TRANSPORT FOR LONDON

M25 JUNCTION 28 IMPROVEMENTS – DEADLINE 4 SUBMISSION

17 MARCH 2021

Client		Project		GROVE FARM ACCESS, JUNCTION 28 M25 NORTHBOUND SLIP LANE	
MR L JONES & MRS K JONES		Title		ACCESS ALTERATIONS TO GROVE FARM	
Status	Drawn	Scale	Sheet Size	Date	Drawing No.
FOR APPROVAL	PL	1:1000	A3	JAN 2021	REDW-3396-110
				Rev

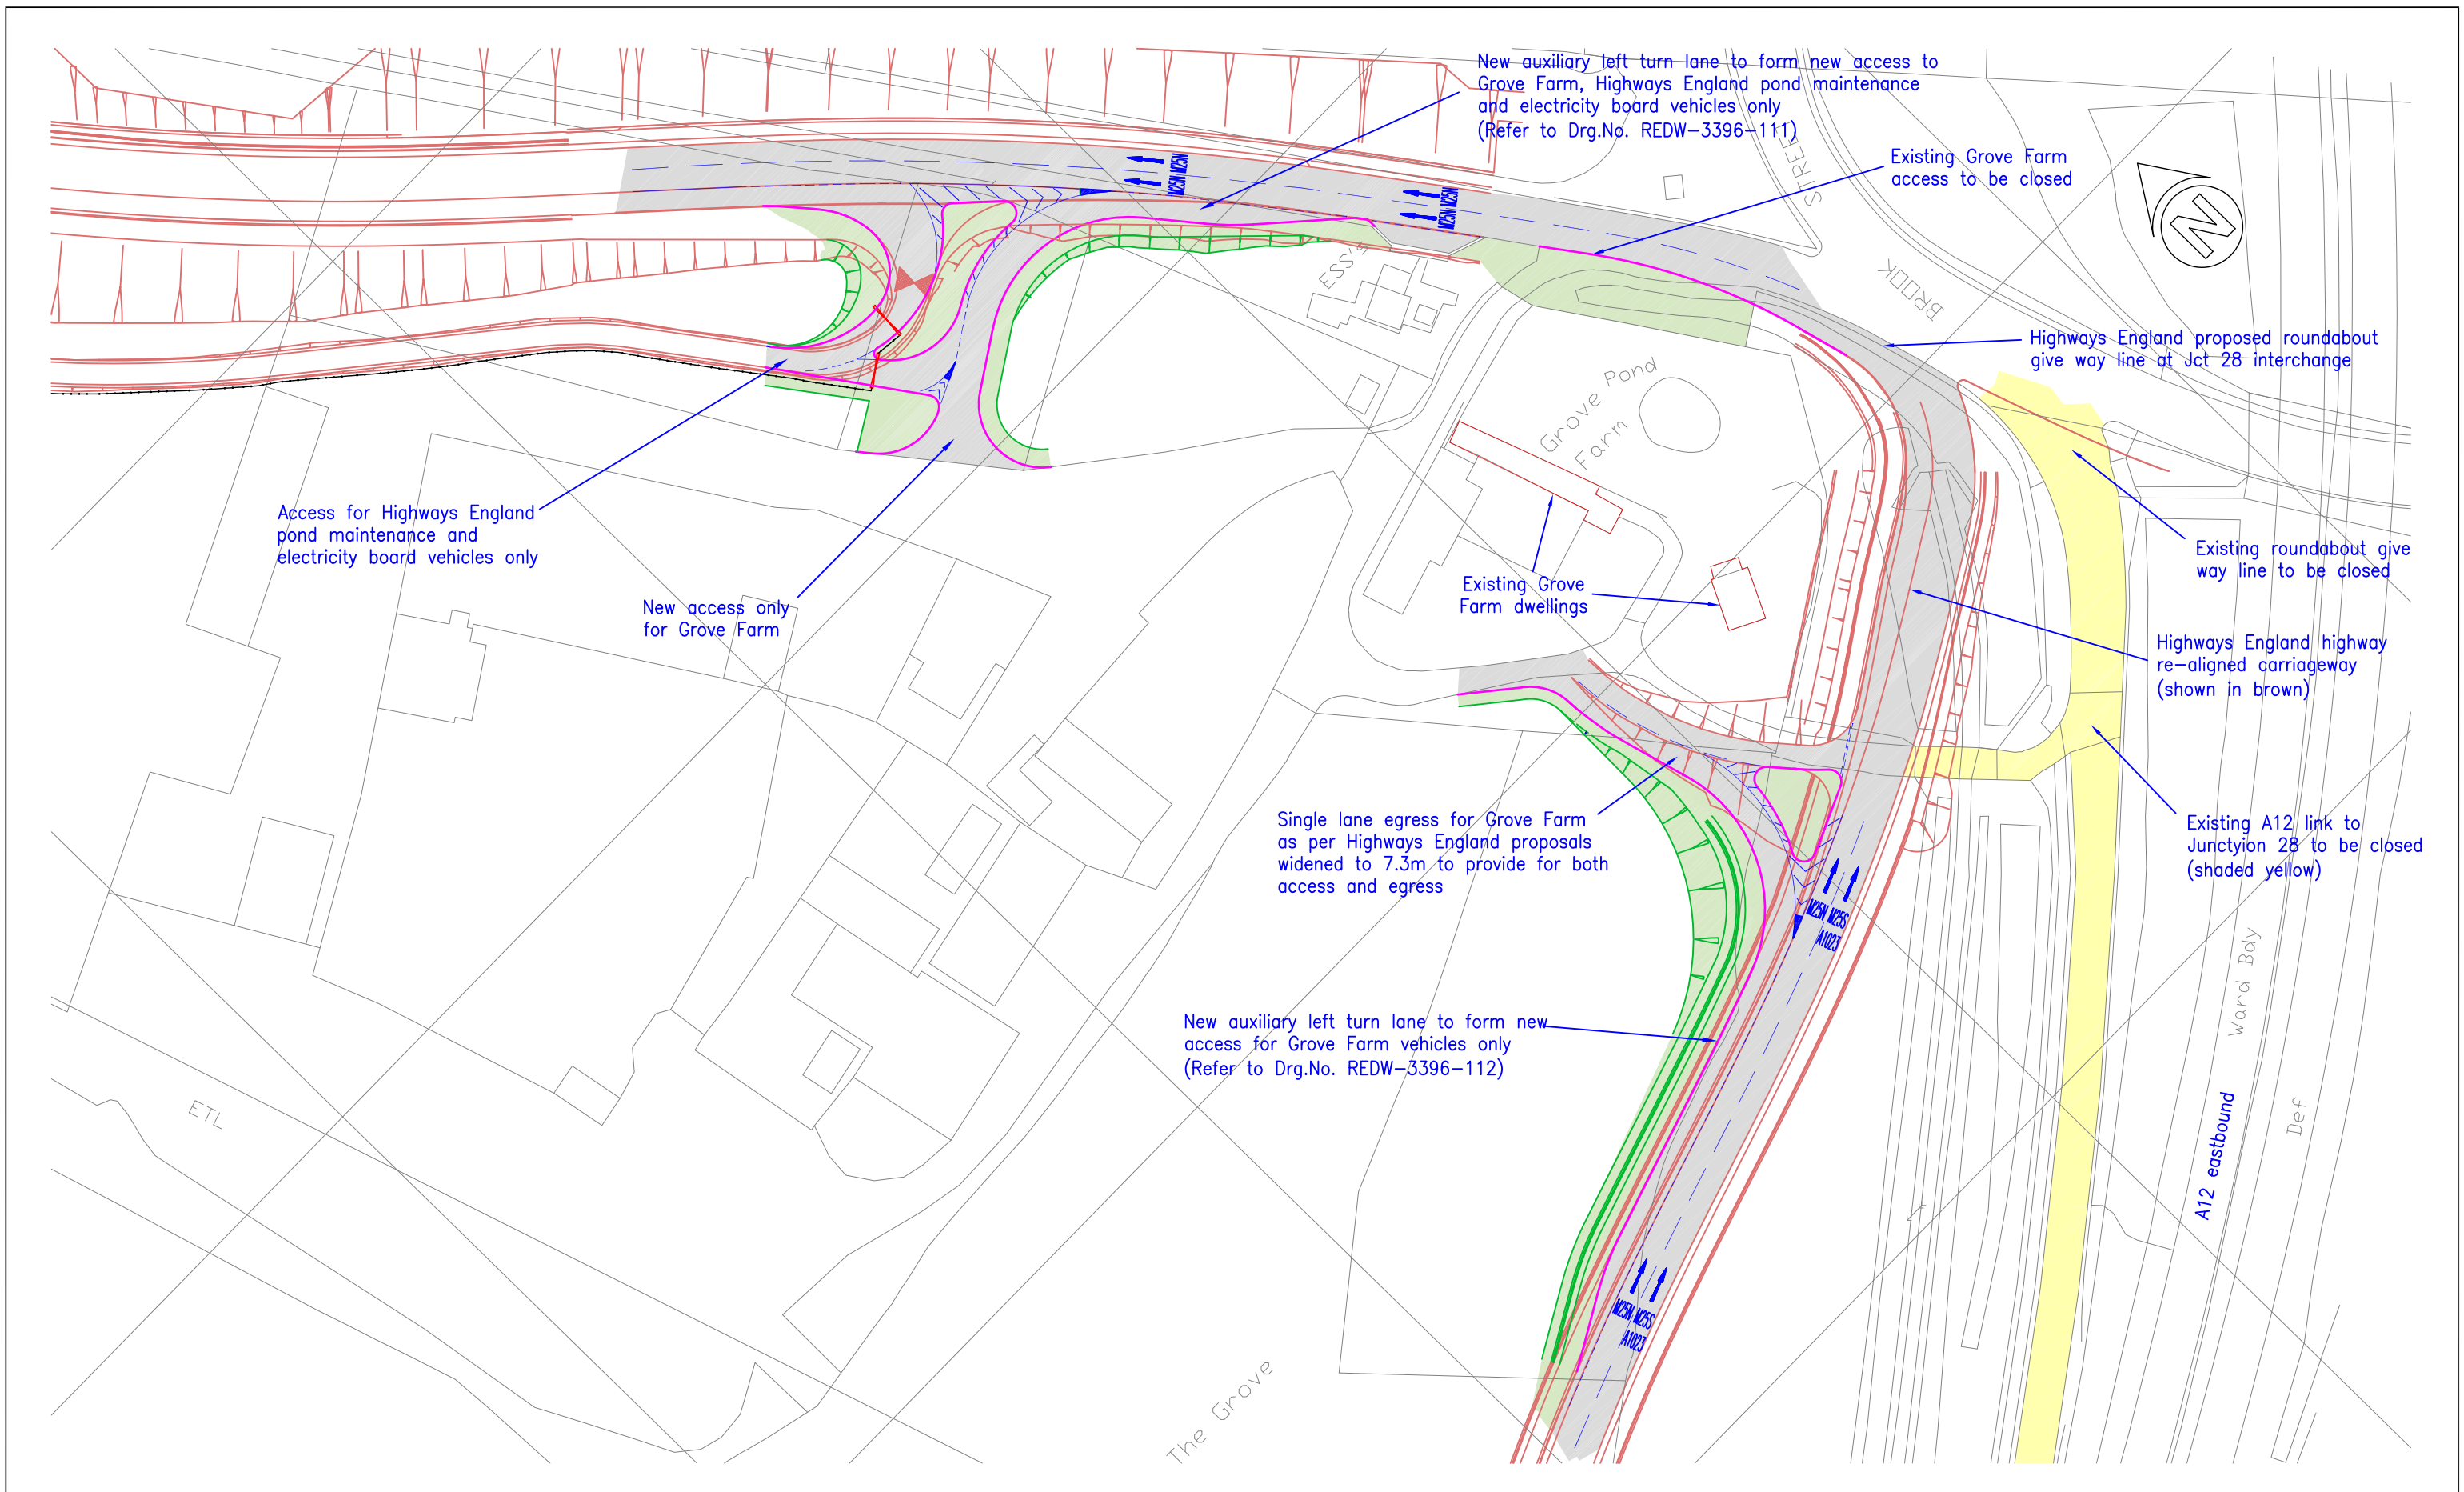
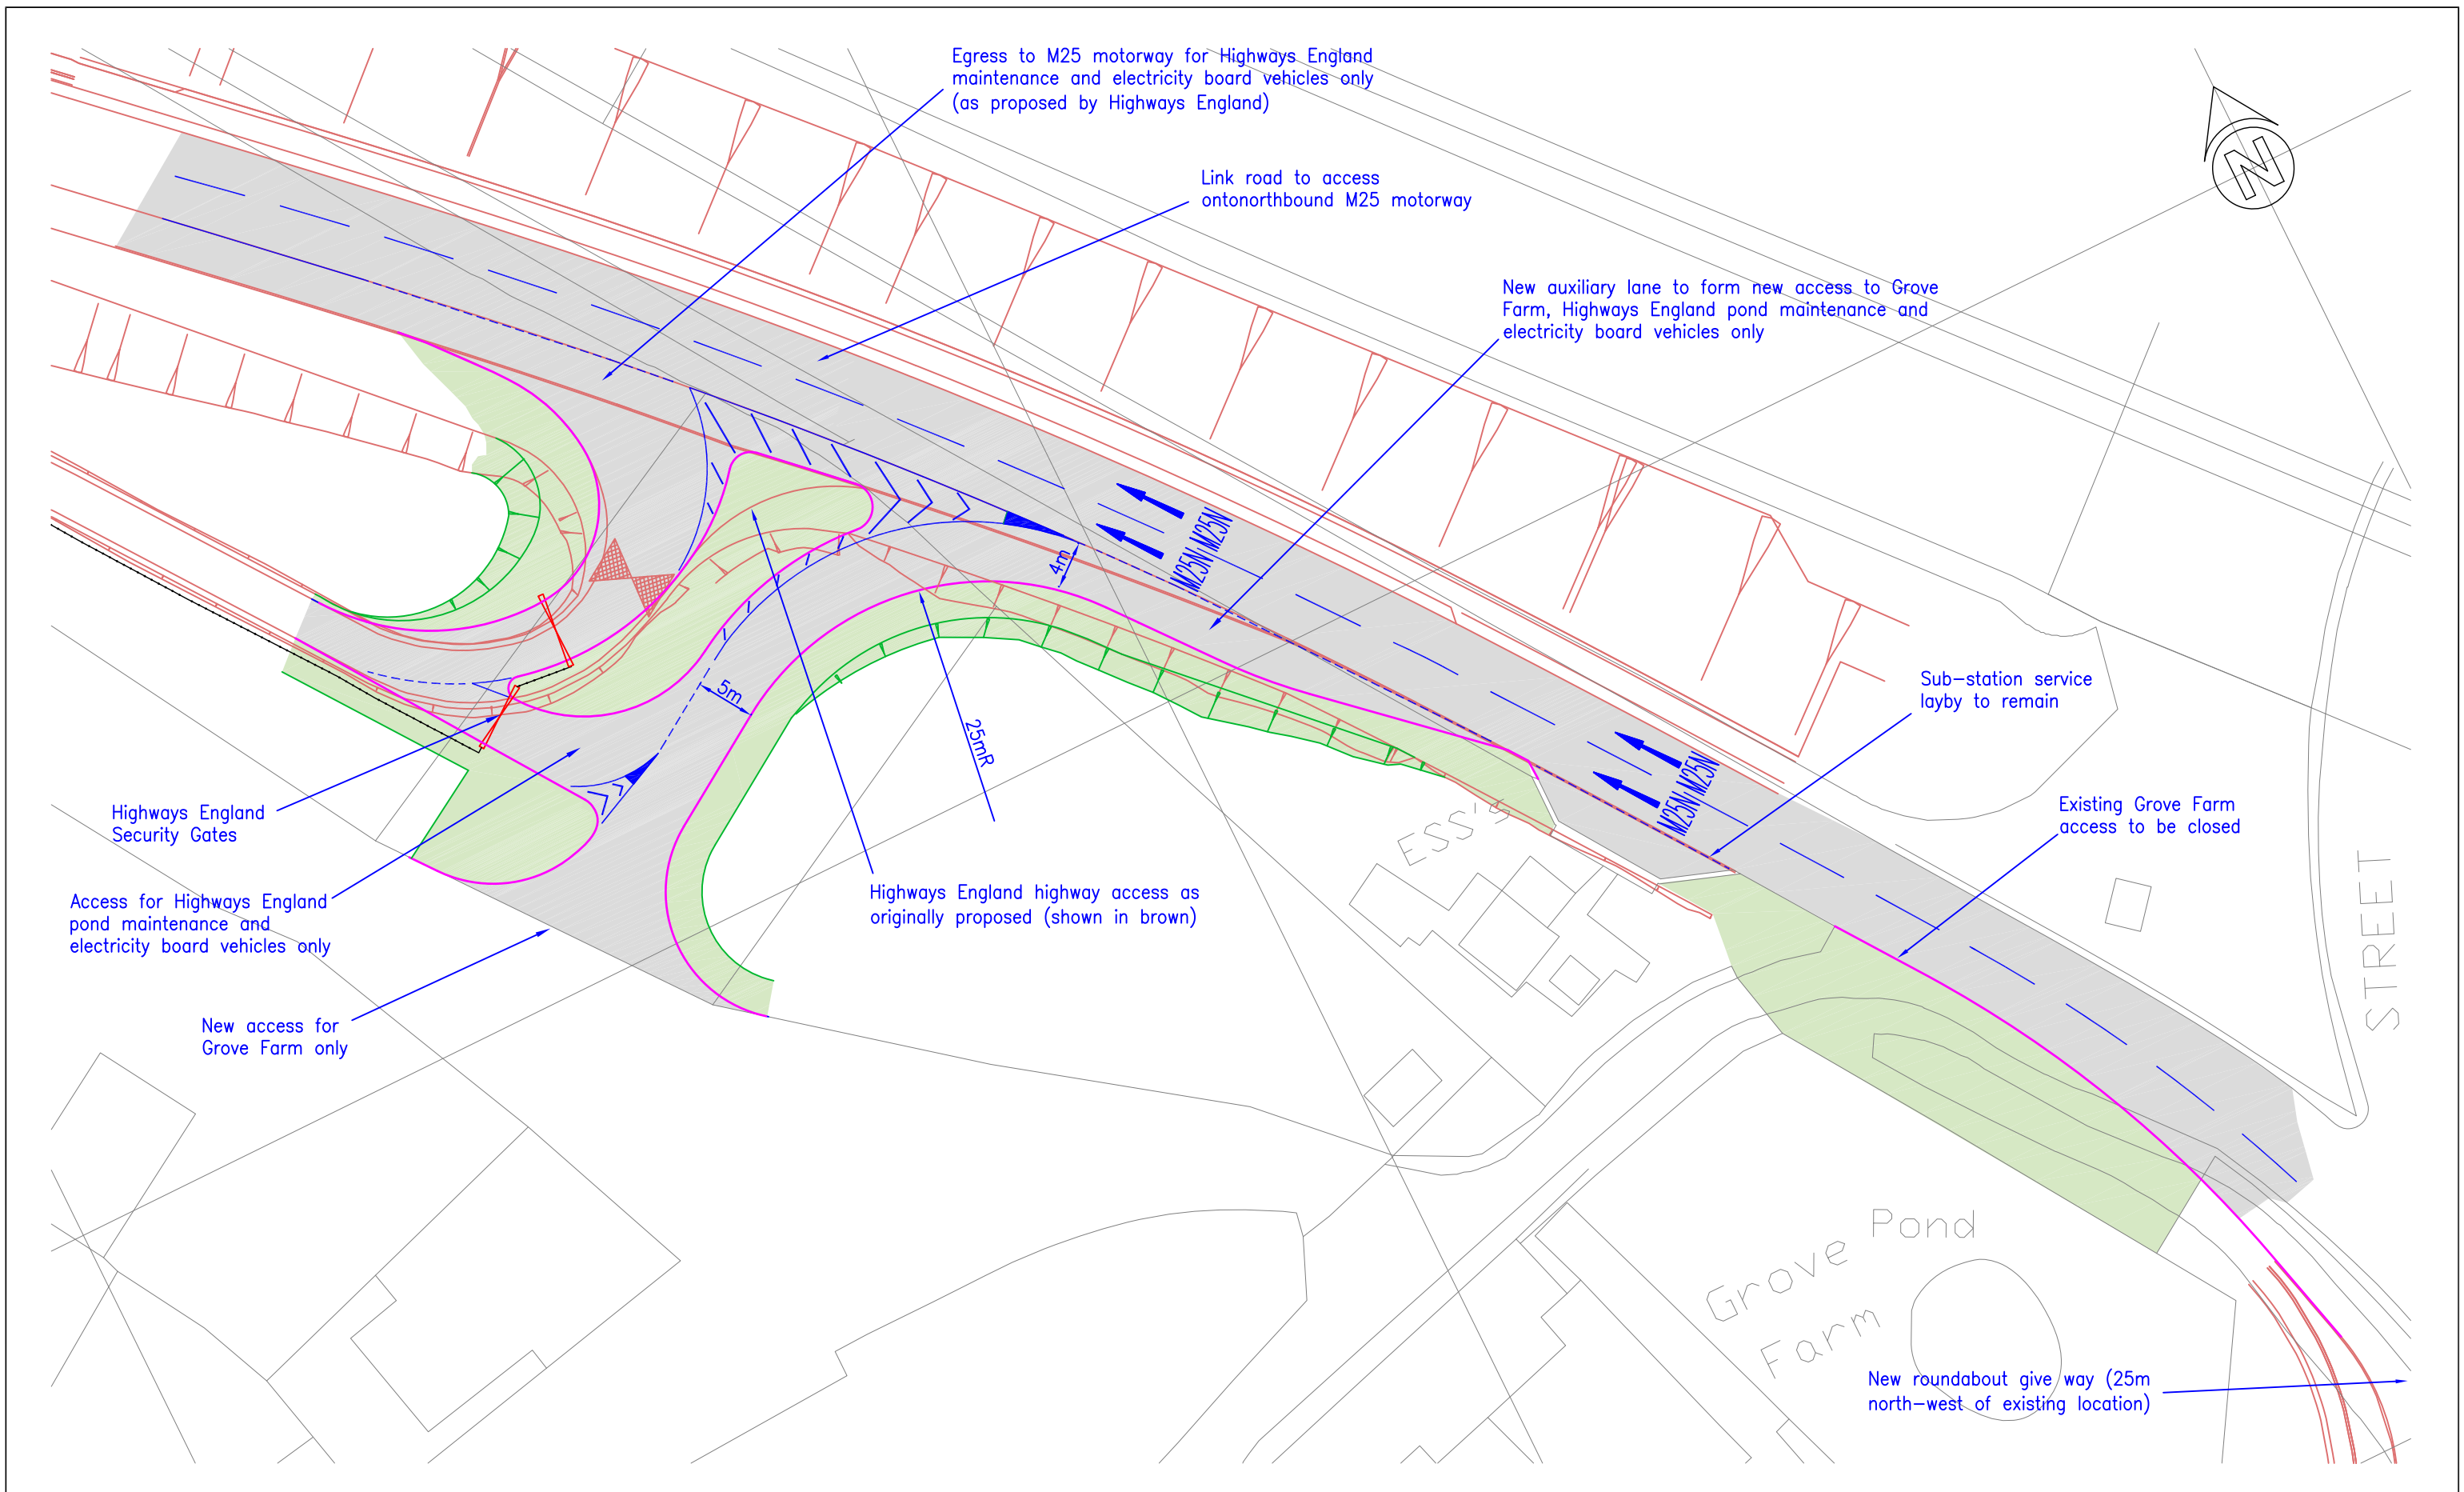
- 3.7.1 TfL set out its views on the proposals for amendments to the access routes to Grove Farm that had been put forward at Deadline 2, noting that it did not wish to comment on the

- 3.7.2 TfL has no issue with the egress from Grove Farm being provided like-for-like, as currently proposed as part of the scheme, if TfL is to take responsibility for the new A12 eastbound off slip road. However, if this egress was converted to also provide an access into Grove Farm, with a left turn only lane provided, TfL considers that there would be an increase in safety related risks on the slip road.

- 3.7.3 The provision of a new access on a slip road may form a departure from the Design Manual for Roads and Bridges (DMRB) standard on the geometric design of grade separated junctions. The DMRB specifies that direct accesses and priority junctions shall not be provided.

- 3.7.4 TfL also notes the concerns raised by the Applicant about the potential for drivers to mistake access to Grove Farm with access to the northbound M25.

- 3.7.5 Considering these points, TfL is broadly in agreement with the Applicant's concerns about increased road safety risks associated with the Grove Farm access proposal, however it is for the Applicant to consider the overall road safety impacts of the proposal as a whole given this also affects road safety on the M25 northbound on slip.
